Please ask for: Ms Iqraa Malik
Email: iqraa.malik@terraquest.co.uk
Telephone: 01212341390
Our Ref: FG/10/21/HH
Your Ref:
Date: 28th January 2021

Application for Planning Permission for Works or Extension to a Dwelling

Development: Single storey side and rear extension following demolition of existing garage
Location: 30 Sea Lane Ferring BN12 5DY

BLOCK PLAN 1:200

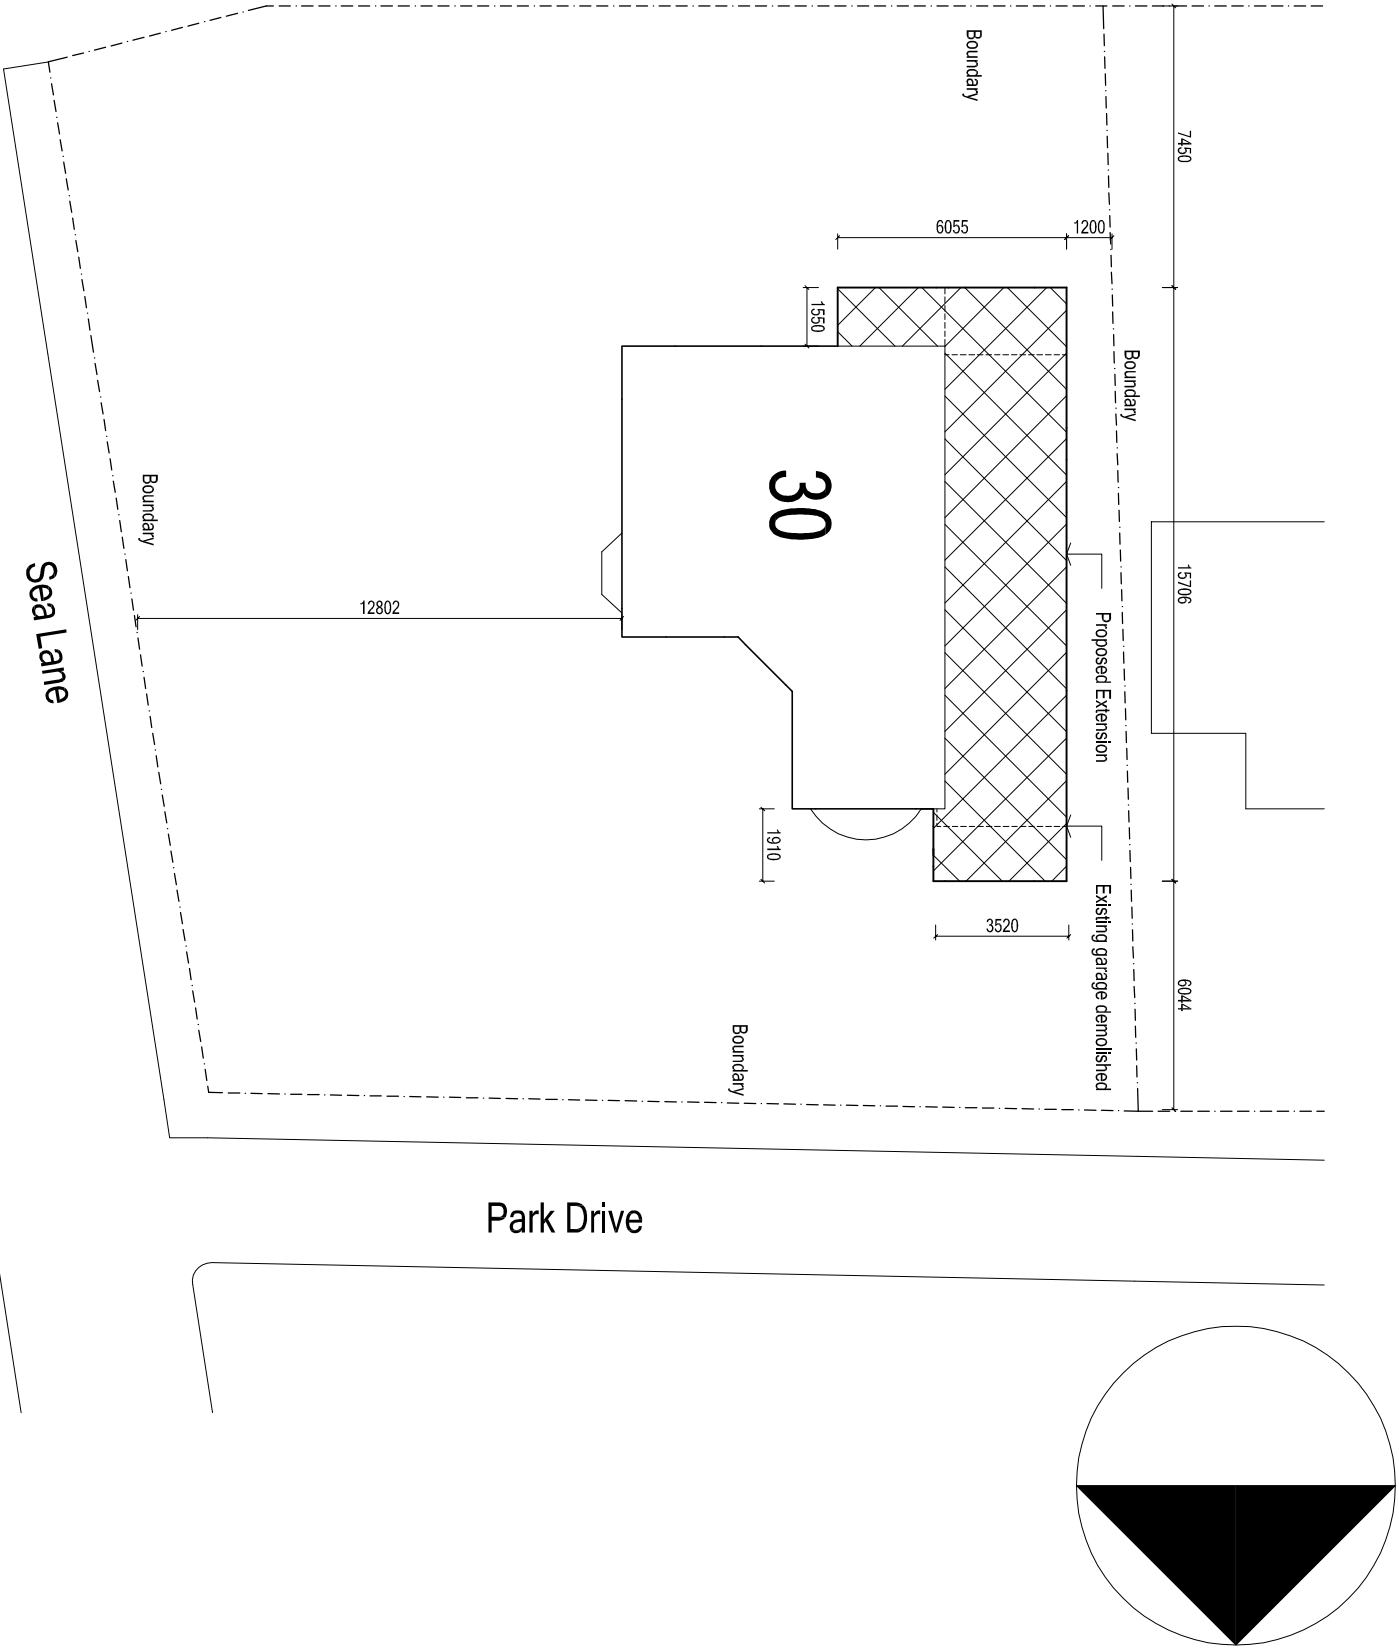
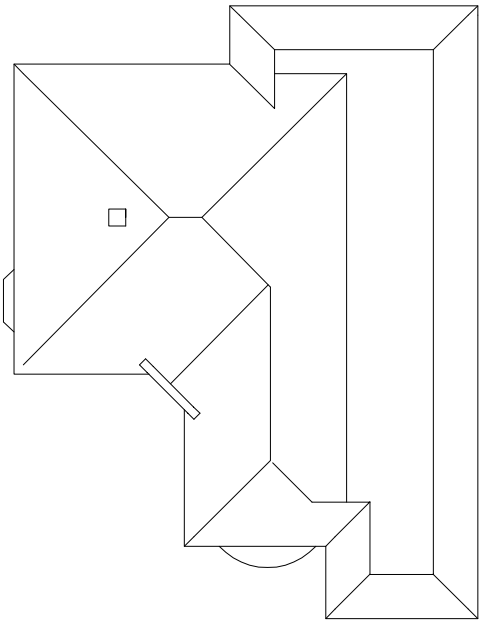
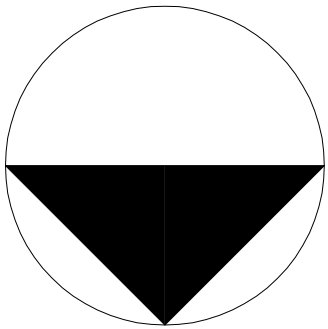
Block Plan

You are required to have dimensions from the proposed extension(s) to all site boundaries. Please amend.
